CITY OF ALBUQUERQUE

October 20, 2021

Re: Presbyterian Hospital Parking Garage
1100 Central Ave SE
30-Day Temporary Certificate of Occupancy
Transportation Development Final Inspection
Engineer's/Architect's Stamp dated 1-6-20 (DRB) (K15D005)
Certification dated 10-15-21

A5 SITE DEMOLITION PLAN
 1" = 20'-0"
 0 10' 20' 40'
 NORTH

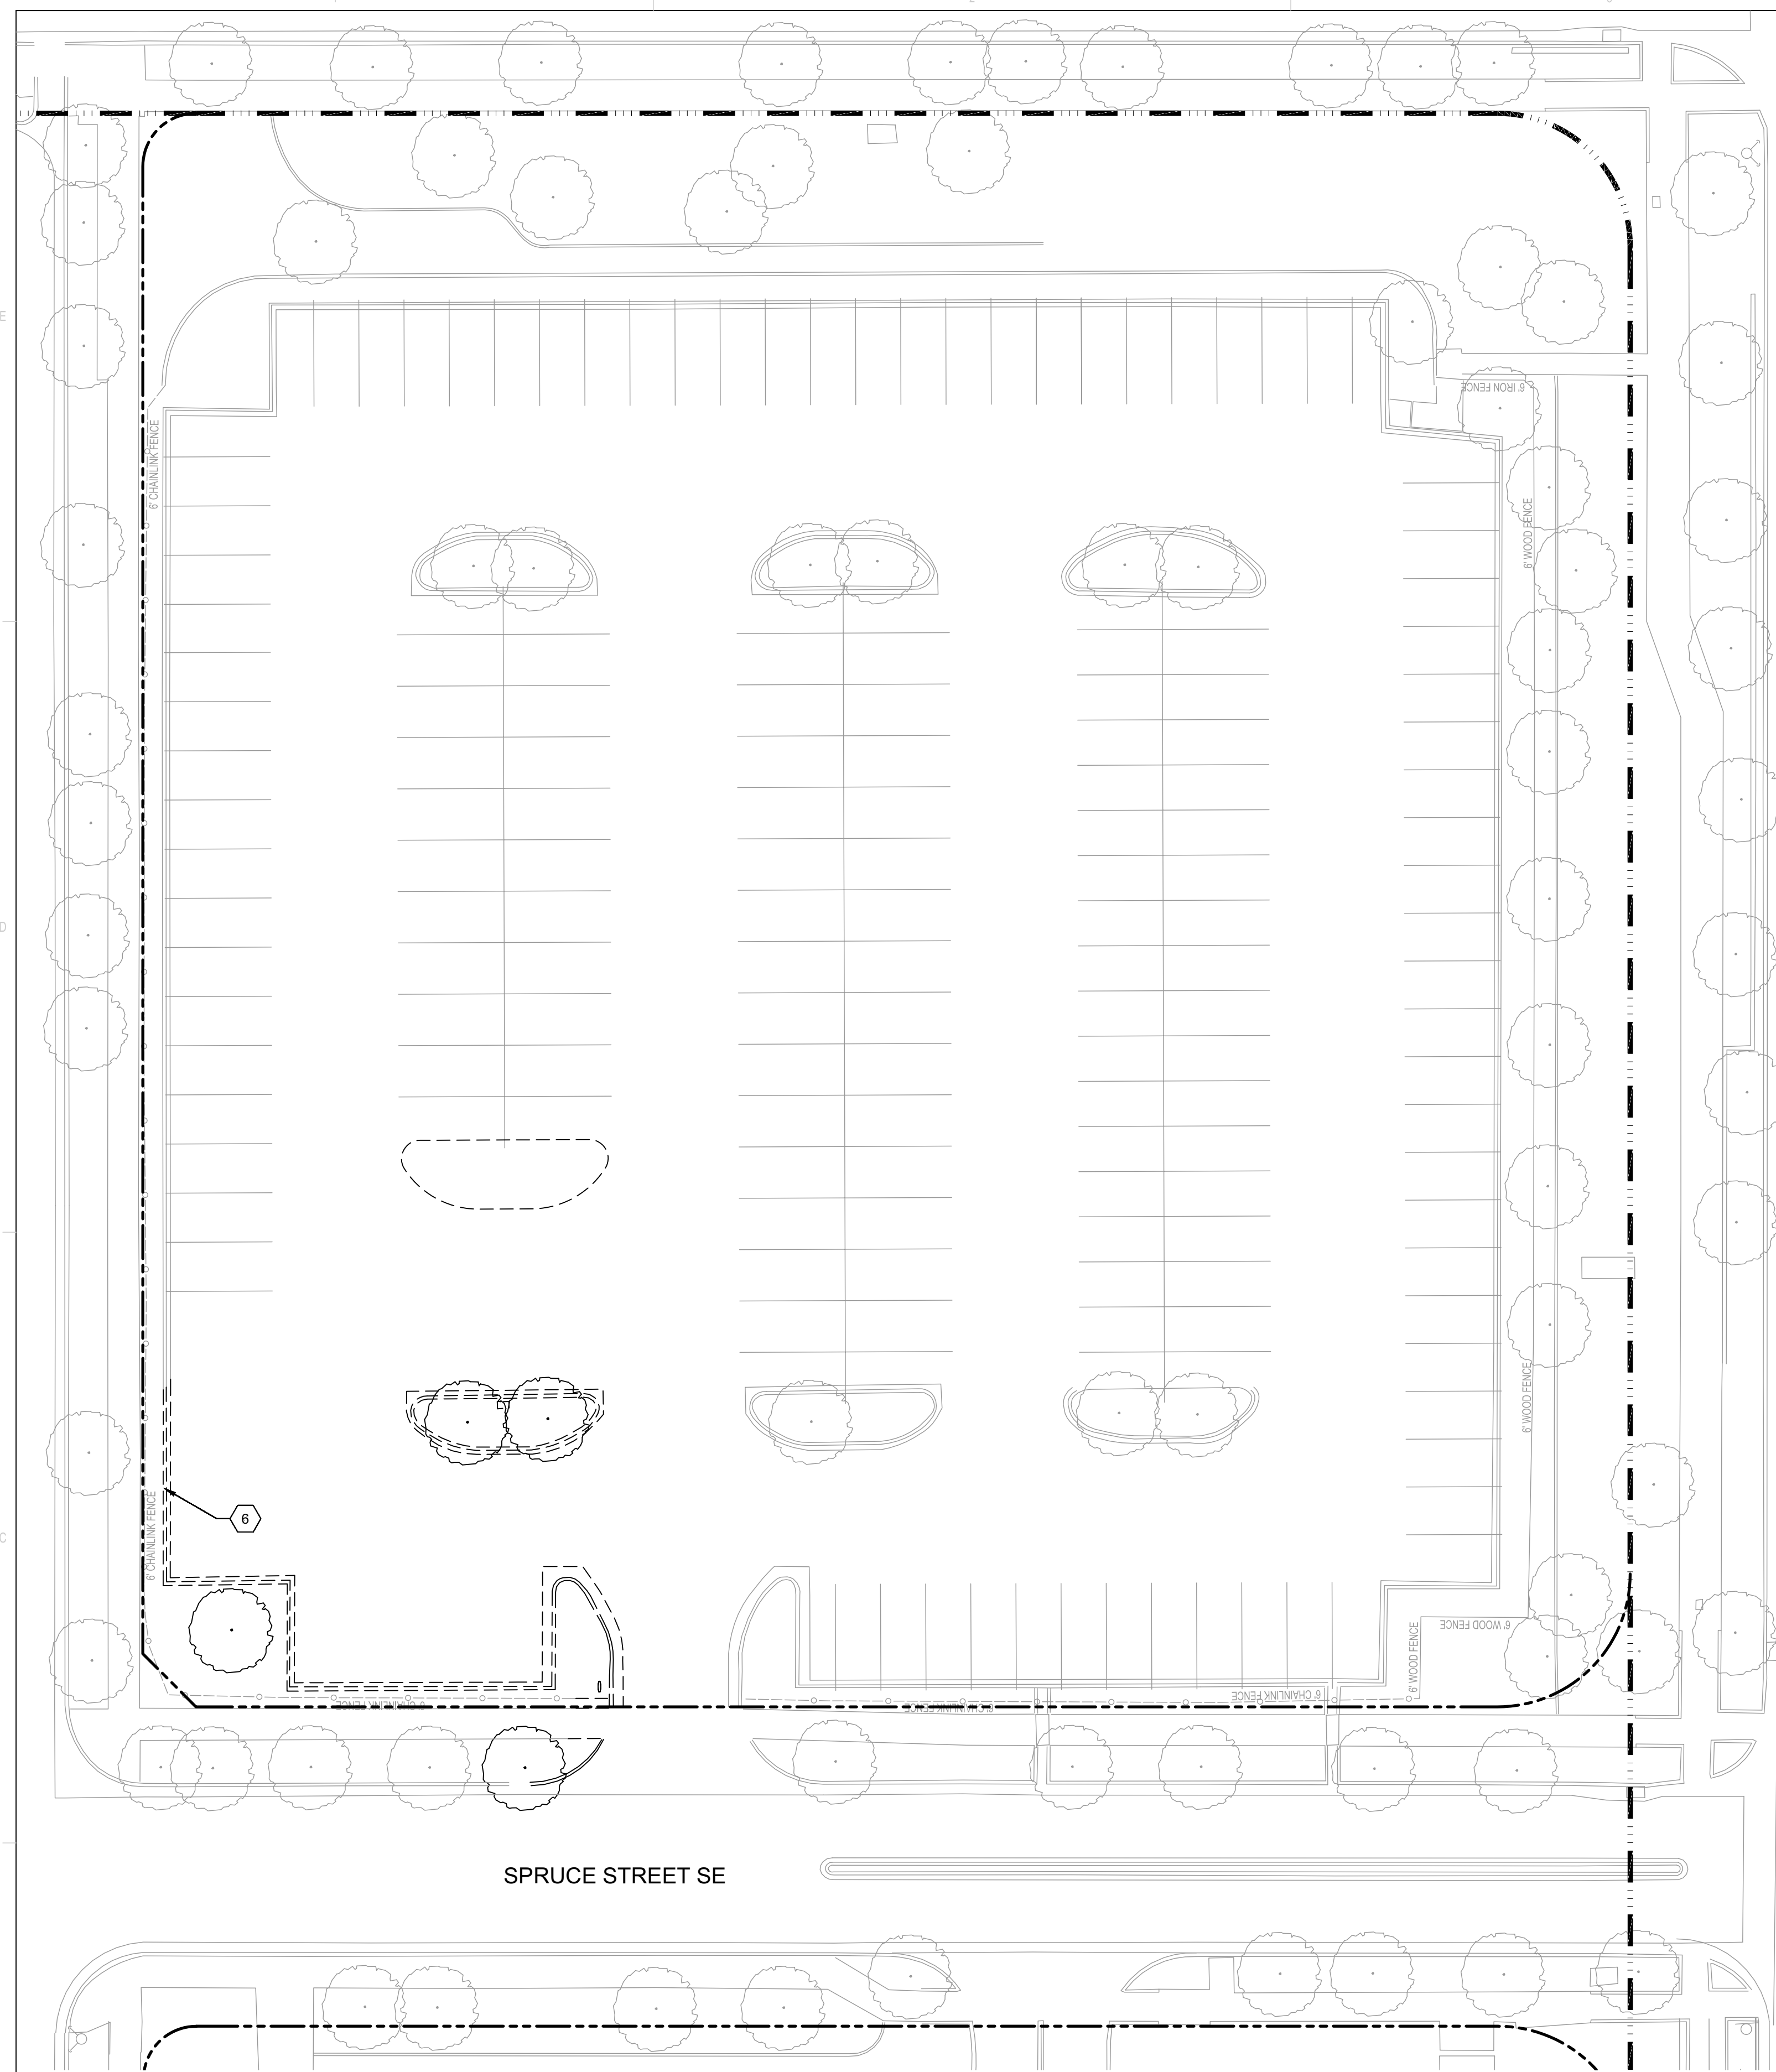
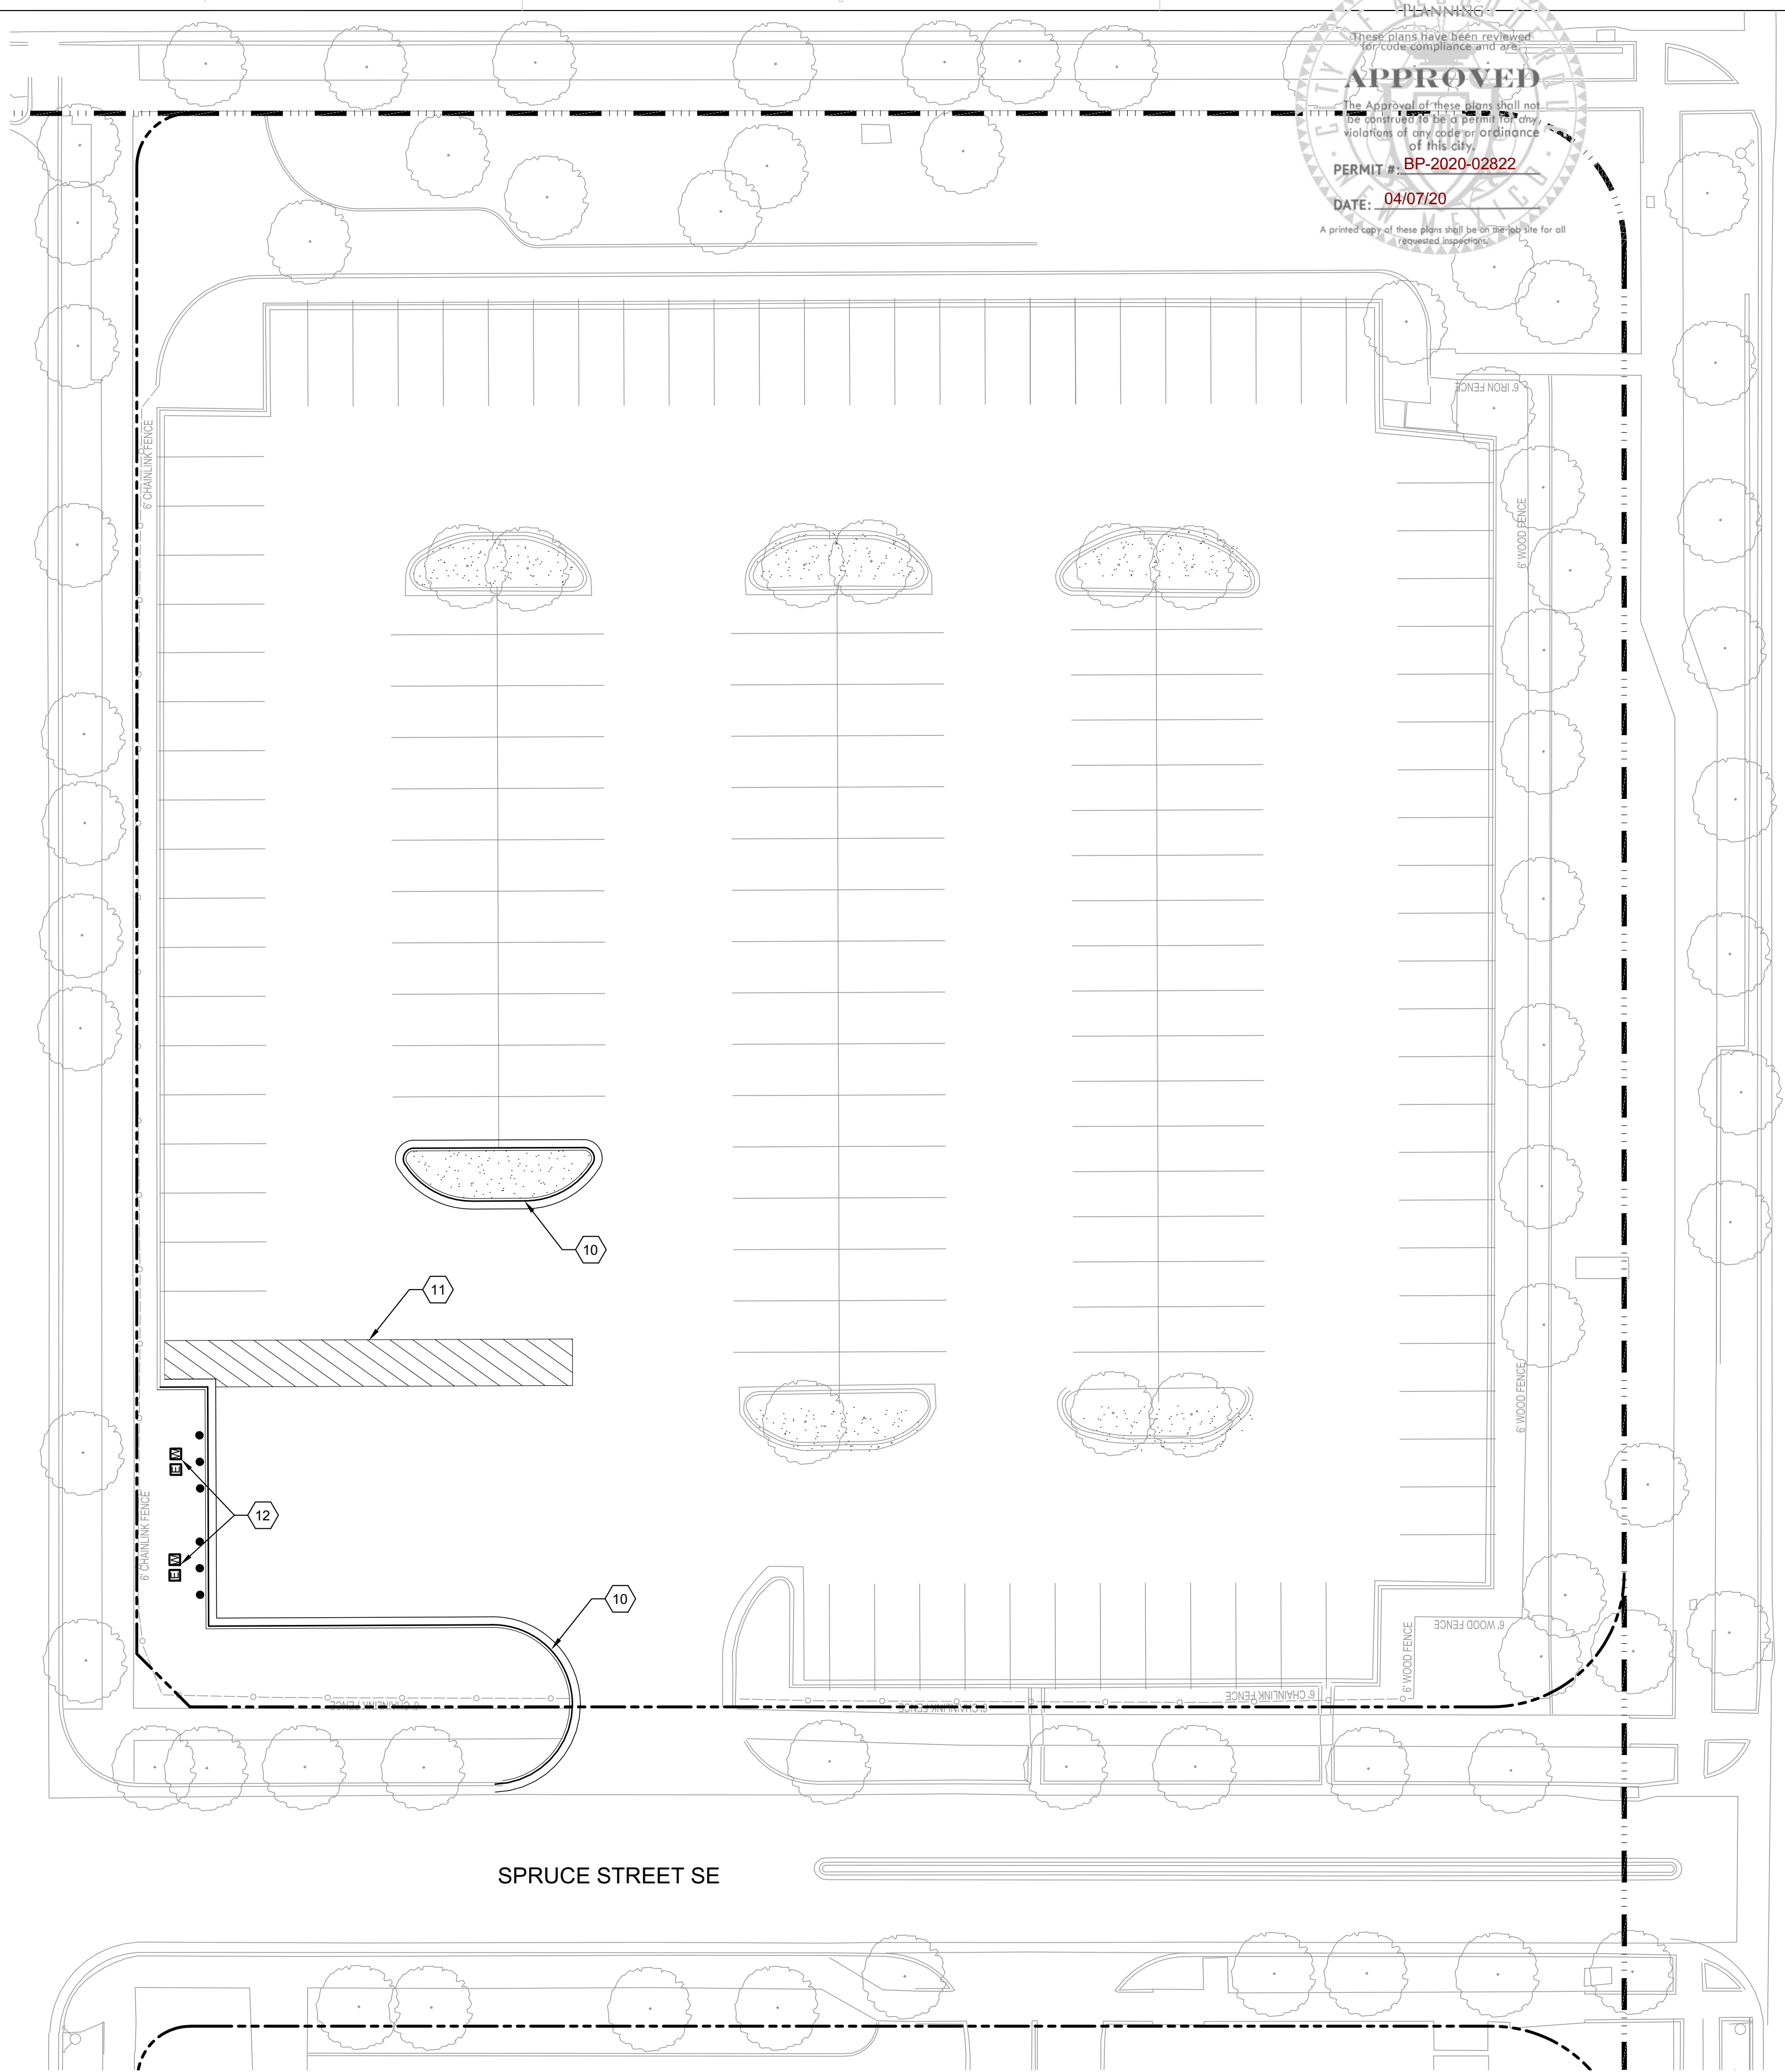
- Please fix broken cracked sidewalk. Truncated domes required for all wheel chair ramps in Public Right of Way.
- Complete Landscaping.
- Remove security fence, construction debris and equipment from site.
